Comhairle Chontae Uíbh Fhailí **Offaly County Council**

CE Report to Elected Members on Strategic Infrastructure Development as required by Section 37E(4) of the Planning and Development Act 2000 (as amended)

Ballinla Wind Farm

An Coimisiún Pleanála Case reference: PAX19.323579

Figure 4-5: Areas to be Felled in Southern Area (in amber) - Excerpt from 23882-MWP-00-00-DR-C-5034

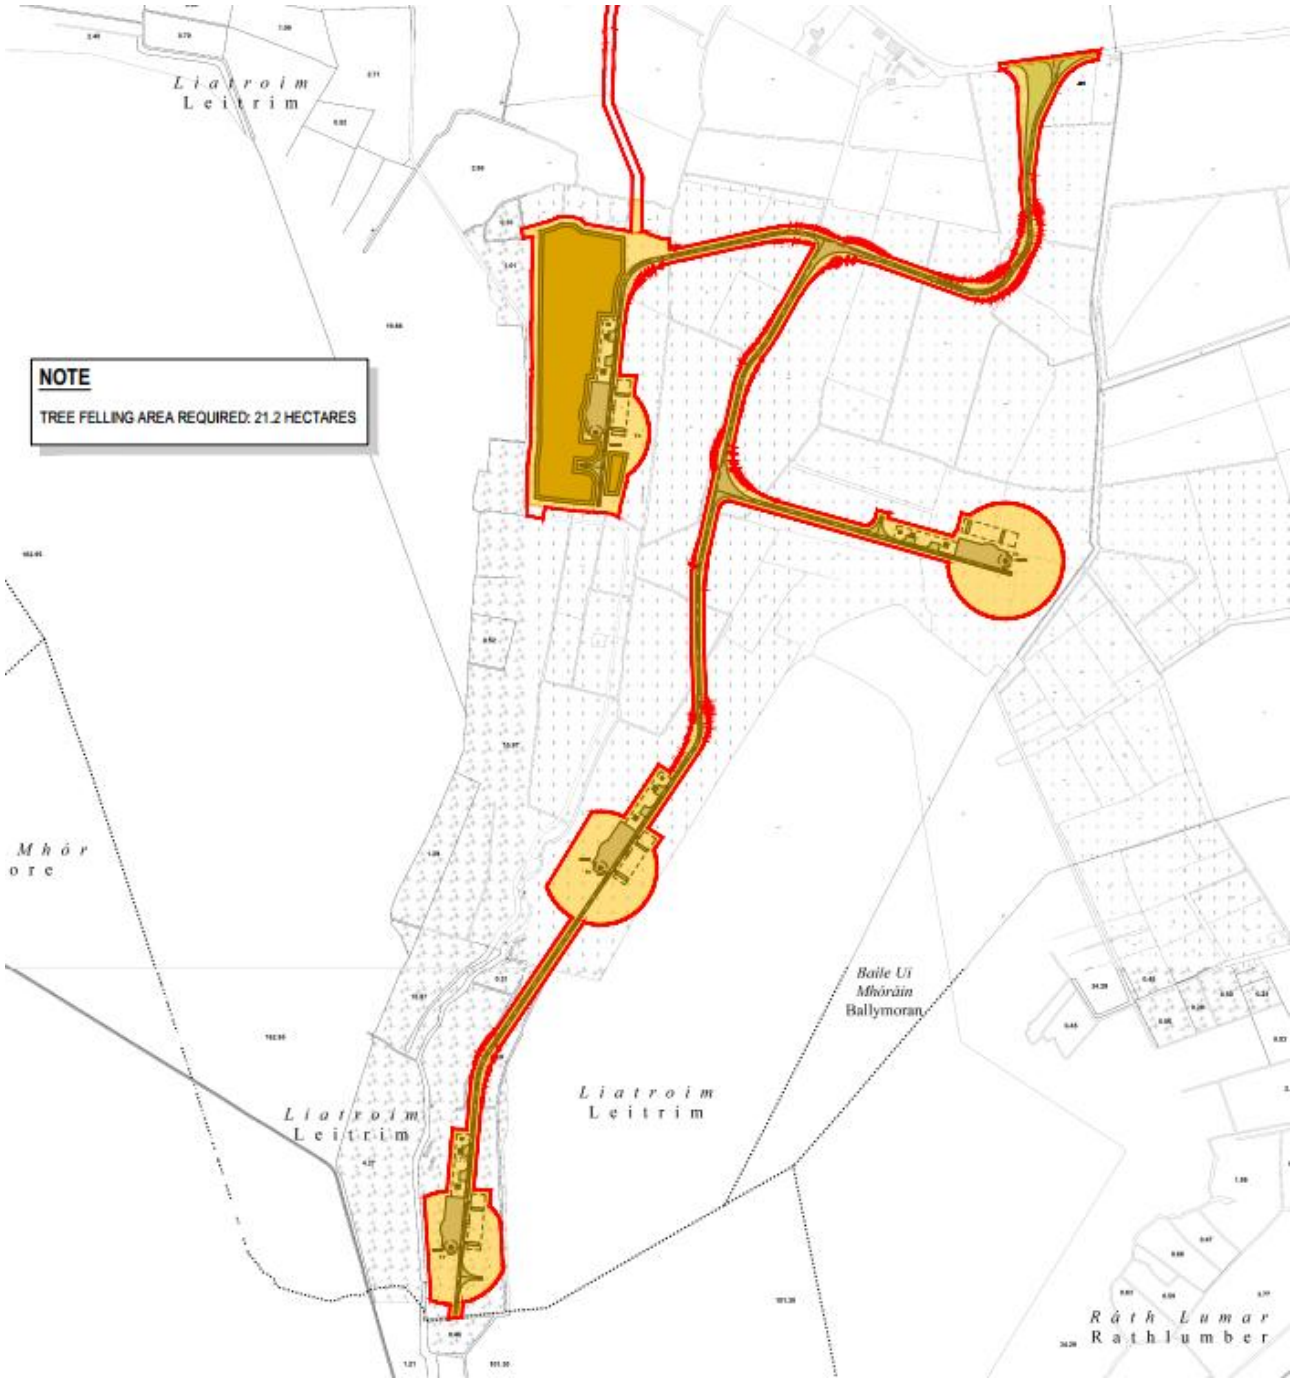
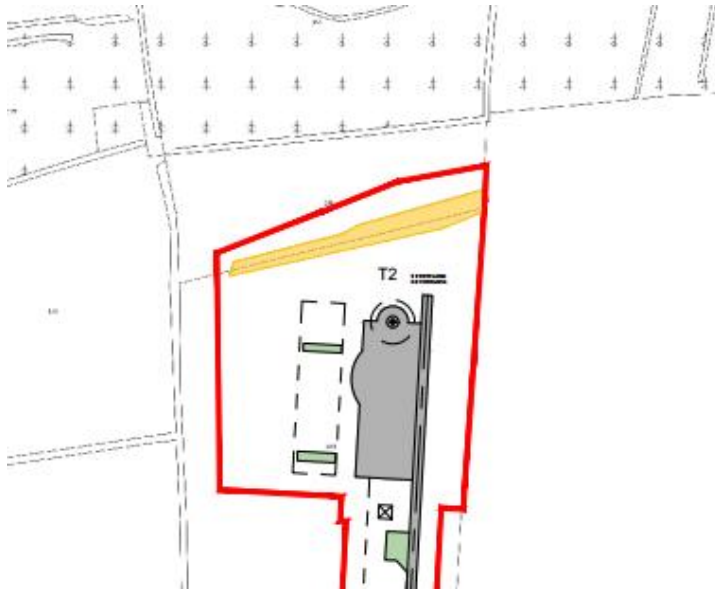
Comment: There is discrepancy in the total area of tree felling that is required to accommodate the proposed development. Both 18ha and 21ha are referred to in the submitted planning documentation; clarification on this area should be sought from the Applicant.
